**KIRKLEES METROPOLITAN COUNCIL  
INVESTMENT & REGENERATION SERVICE**

**DELEGATED DECISION TO DETERMINE PLANNING APPLICATIONS**

**Reference No:** 2019/62/93712/W  
**Site Address:** land off, Coniston Road, Meltham, Holmfirth, HD9 4BY  
**Description:** Erection of stables and formation of access track  
**Recommending Officer:** Ellie Worth

DRAWING TITLE
 PROPOSED FLOOR PLAN AND
 ELEVATIONS

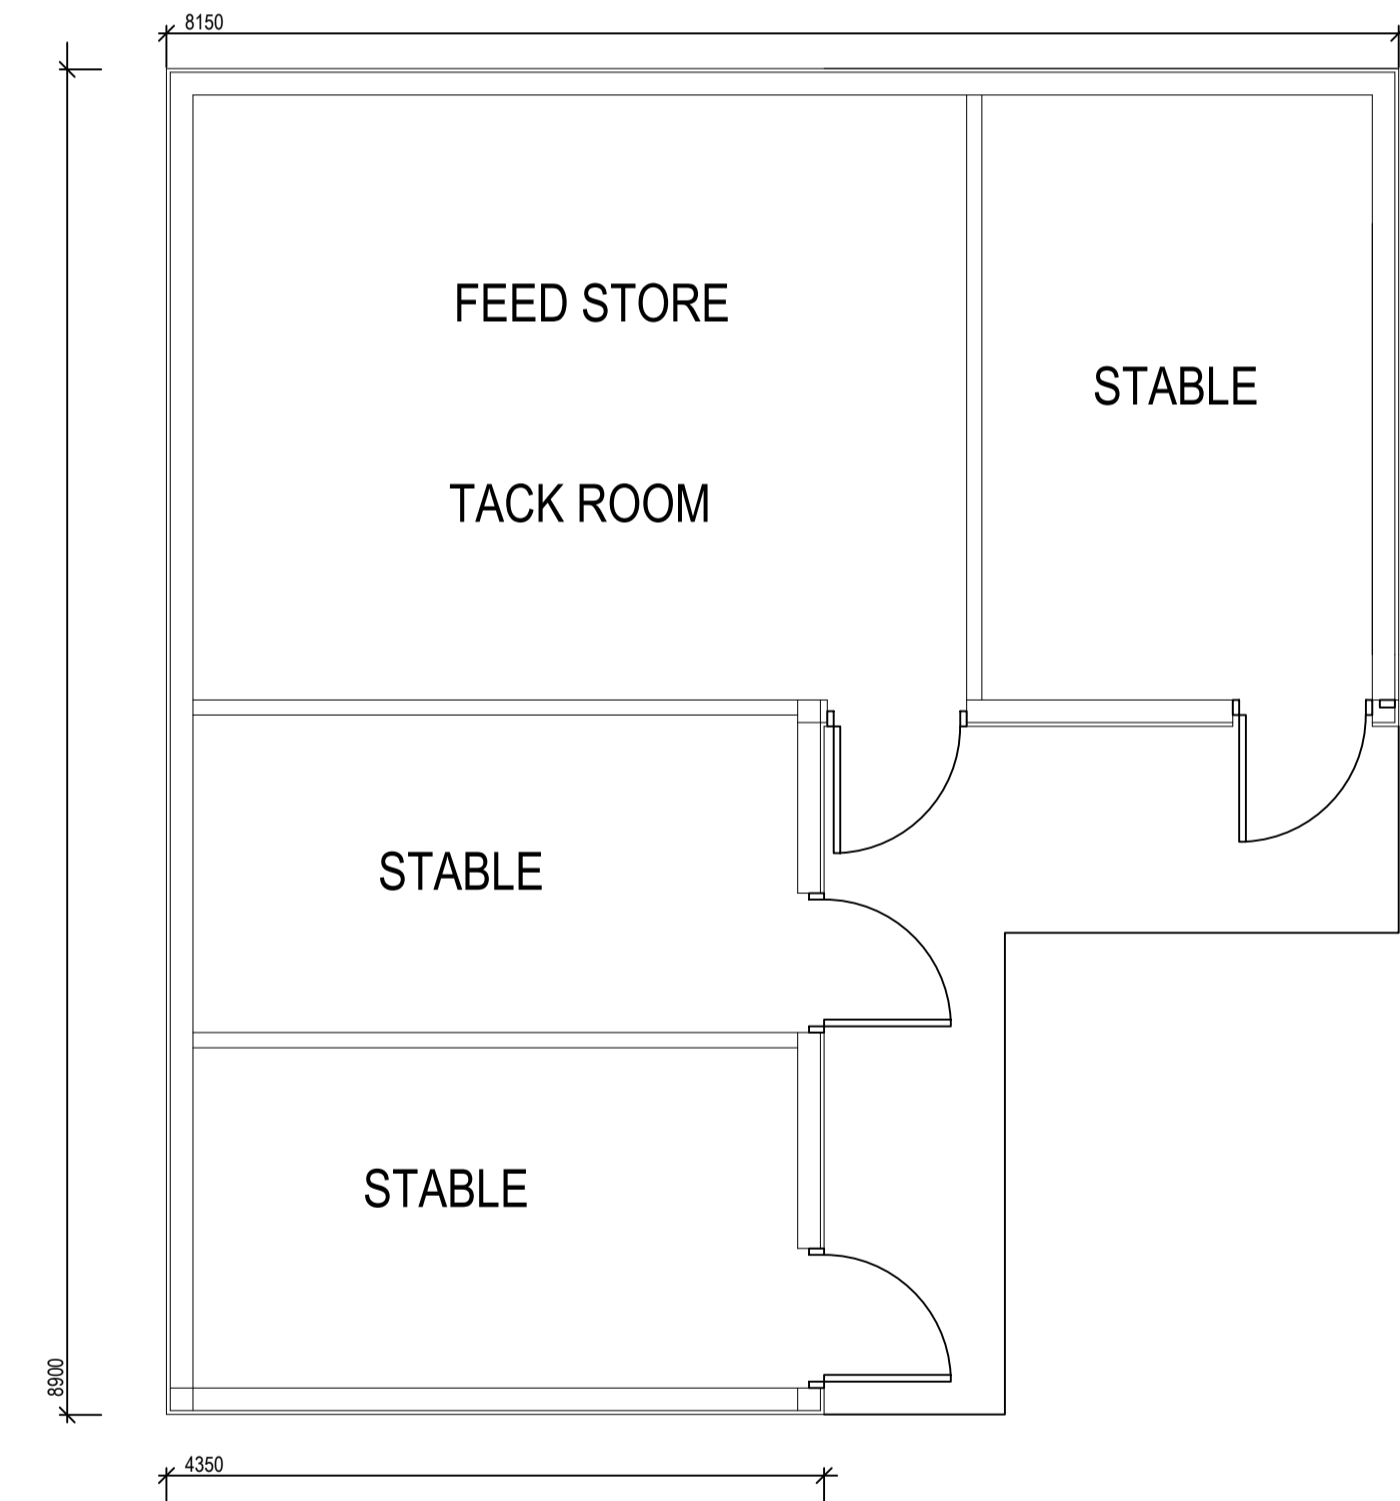
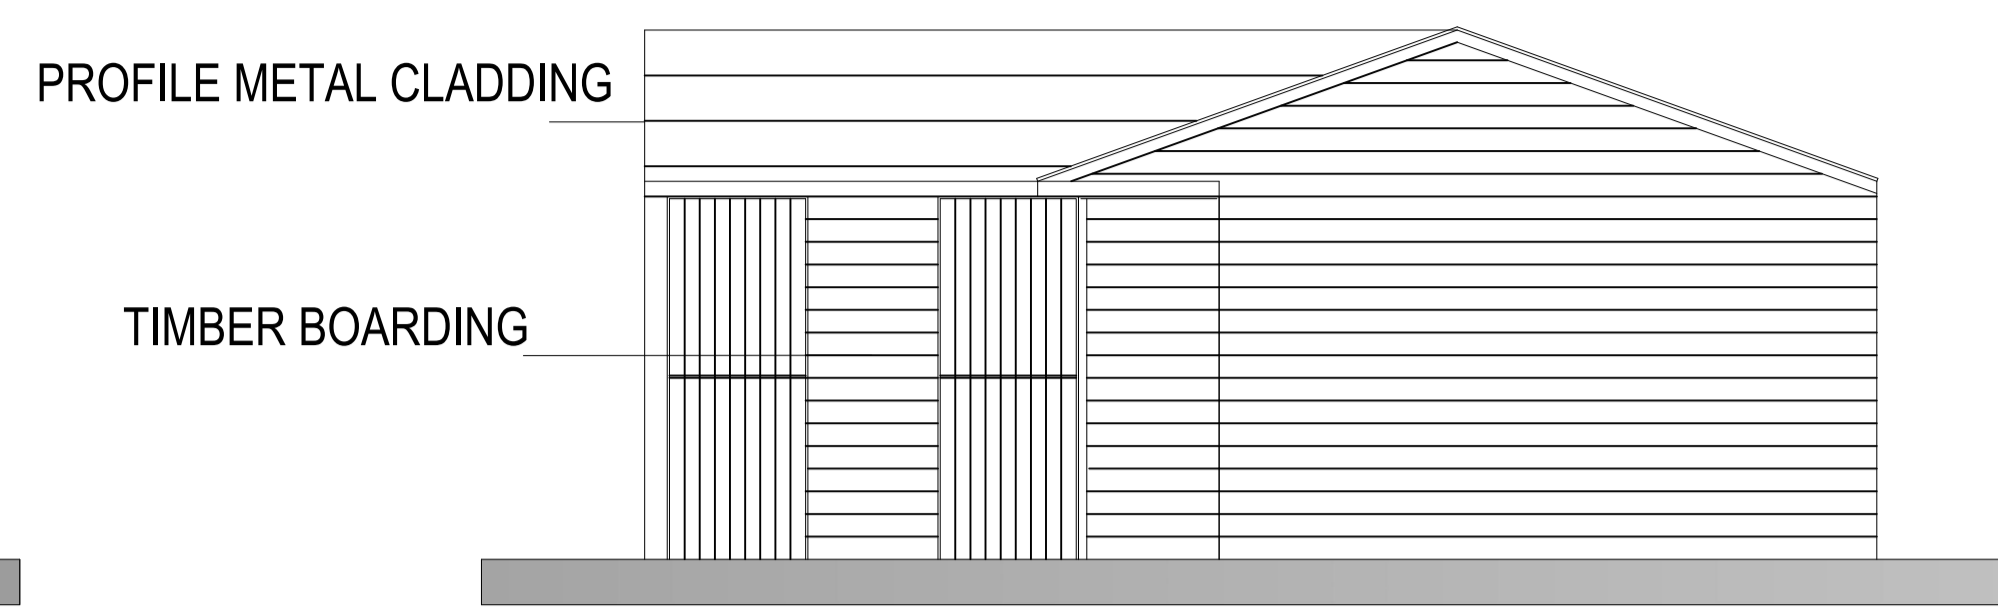
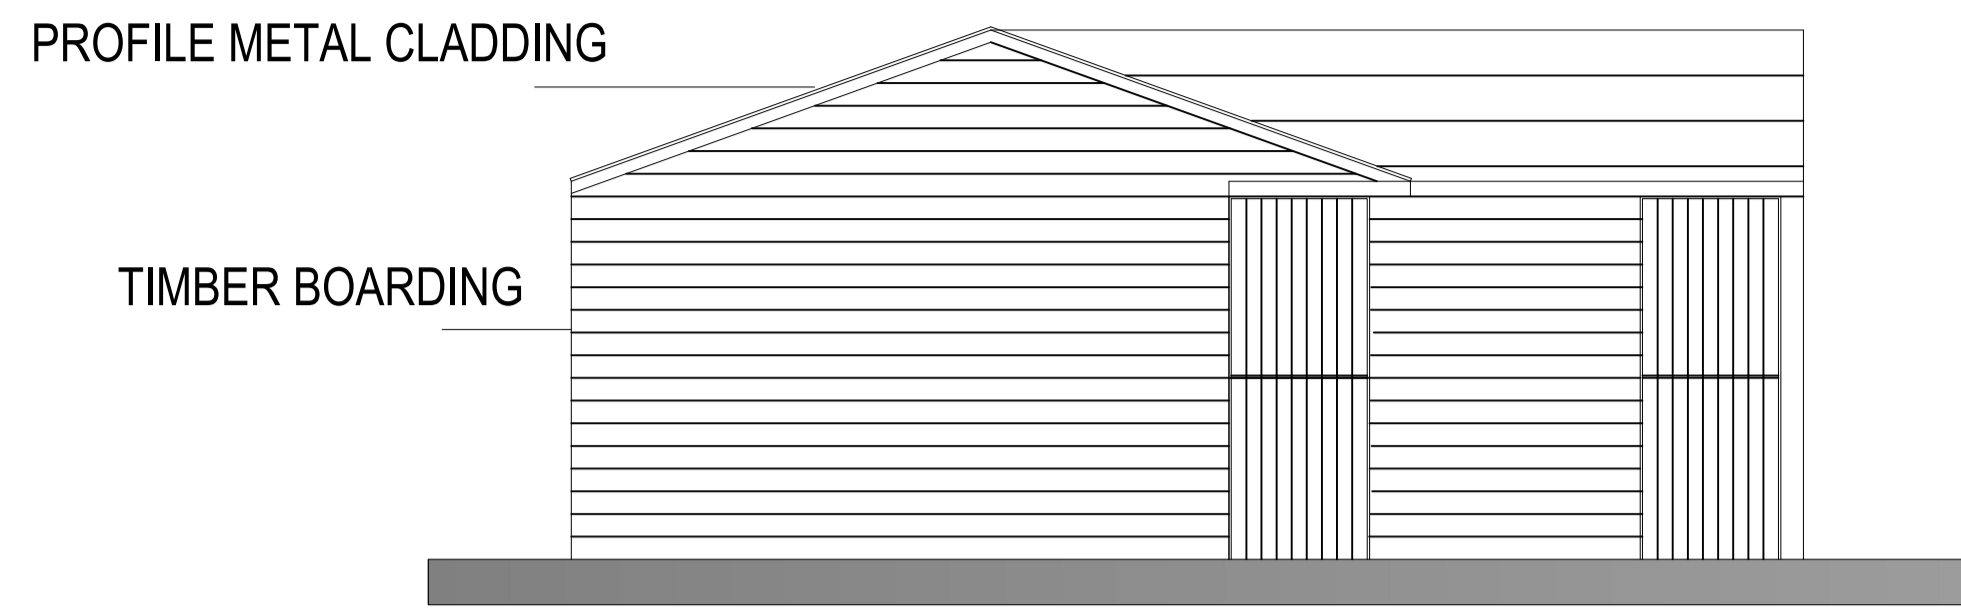
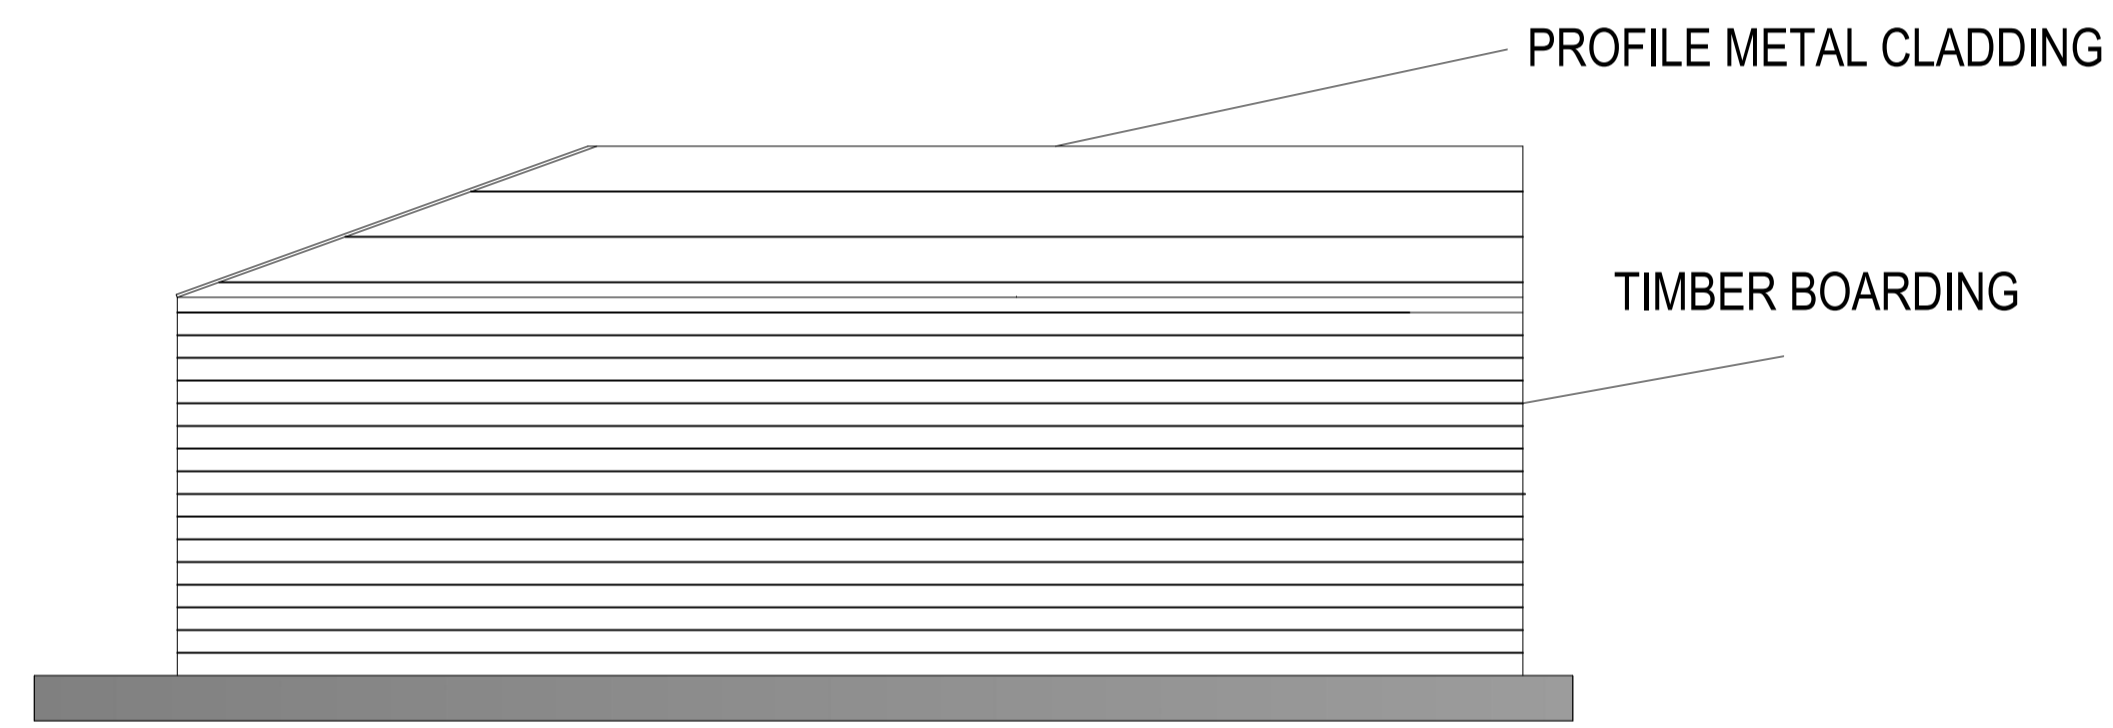
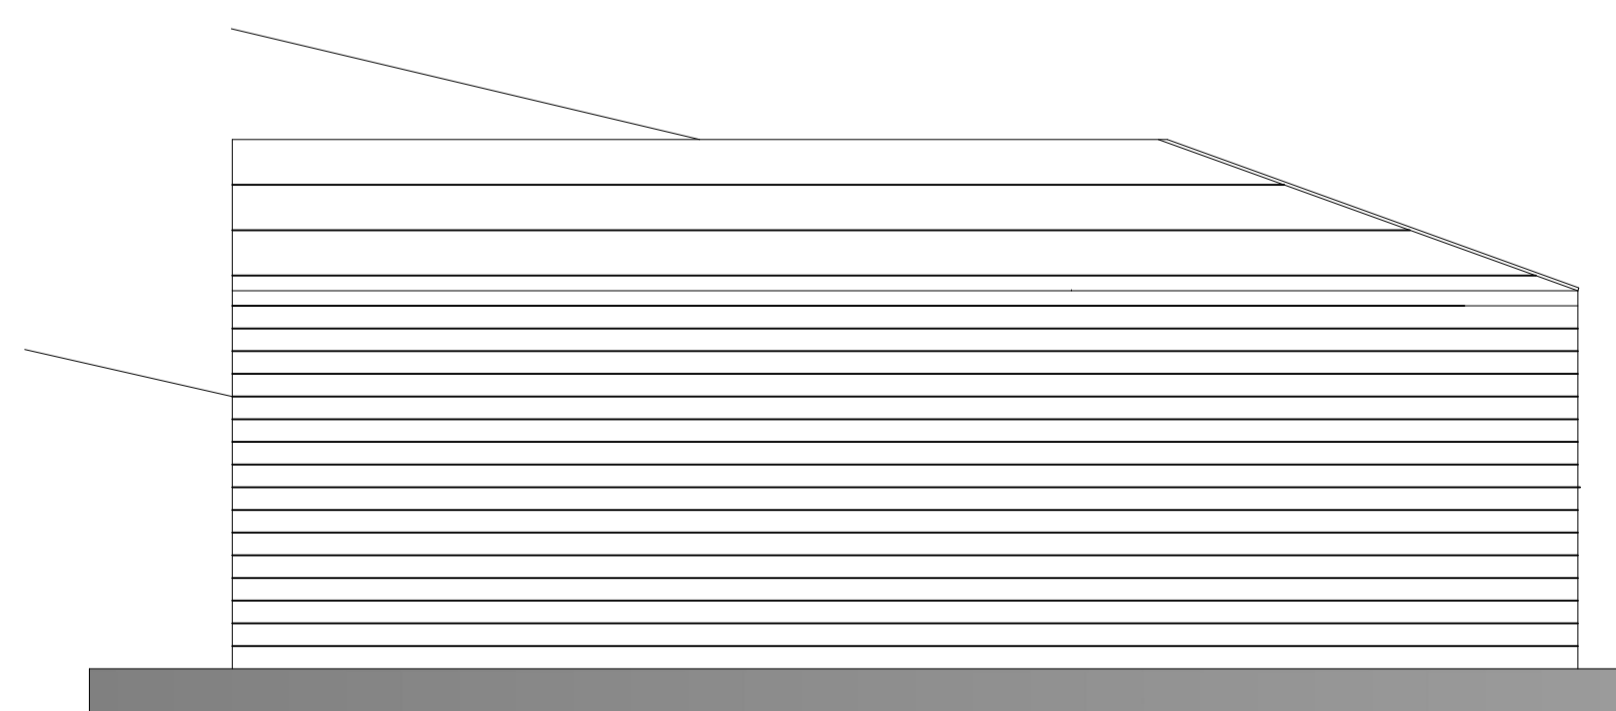
In this instance, the officer entered into several discussions with the agent in order to reduce the overall size and scale of the stable block to provide a more traditional design. As such, final amended plans were received on the 6<sup>th</sup> February 2020, to show a 'L' shaped stable block in which would be tucked into the corner of the field. The building would also be located on a fairly level land, which is not considered to require significant ground works.

The design and materials of the stable block would be appropriate for such a structure. The stables would be positioned at one end of the land at a lower level than the access track which would help to ensure that the stables are not overly prominent in the local area and is unobtrusively positioned.

The development includes 3 individual stables and a combined feed store and tack room. The applicant has detailed that up to 3 horses could occupy the site and the agent has also confirmed that the site is accompanied by 1.6 – 1.8 hectares of land with the stables only being used by the applicant for private use. Such a level of land is considered to be sufficient for up to 3 horses. The tack room and feed store would aid the function of the stable block and are considered to be of an appropriate size providing associated functional accommodation proportionate to the use.
